LU/258/18/L

Application for listed building consent for propping canopy and supporting timber posts, demolition and reinstatement of the balcony

Revision:	Date:	Description:
Hobdens		
16 South Terrace, Littlehampton		
REPAIRS TO BALCONY

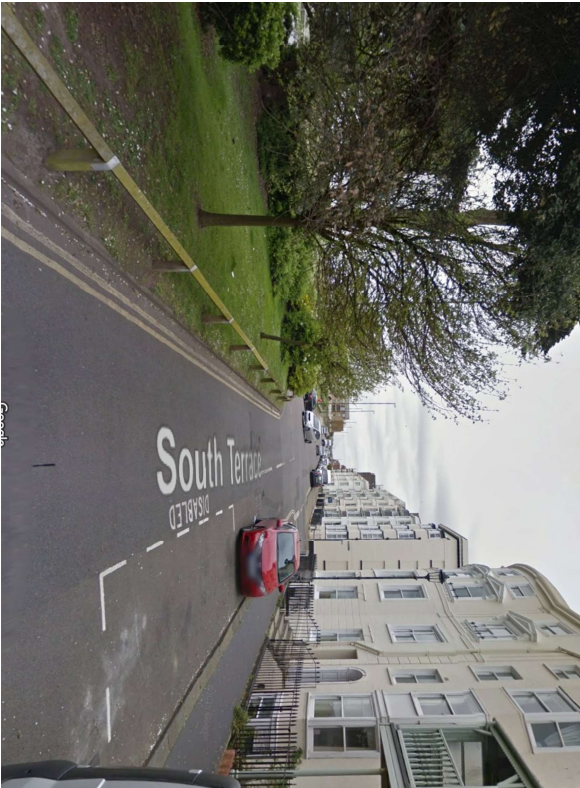
In order to ensure that the works are undertaken on a 'like-for-like' basis, you may wish to request some more detailed pictures of the existing beams etc. are taken prior to the commencement of works in order to ensure that any replacement ones are the same.

All of the colours of the wood and metal work should match the existing. If any colour is to change, this will require the submission of a separate Listed Building Consent application.
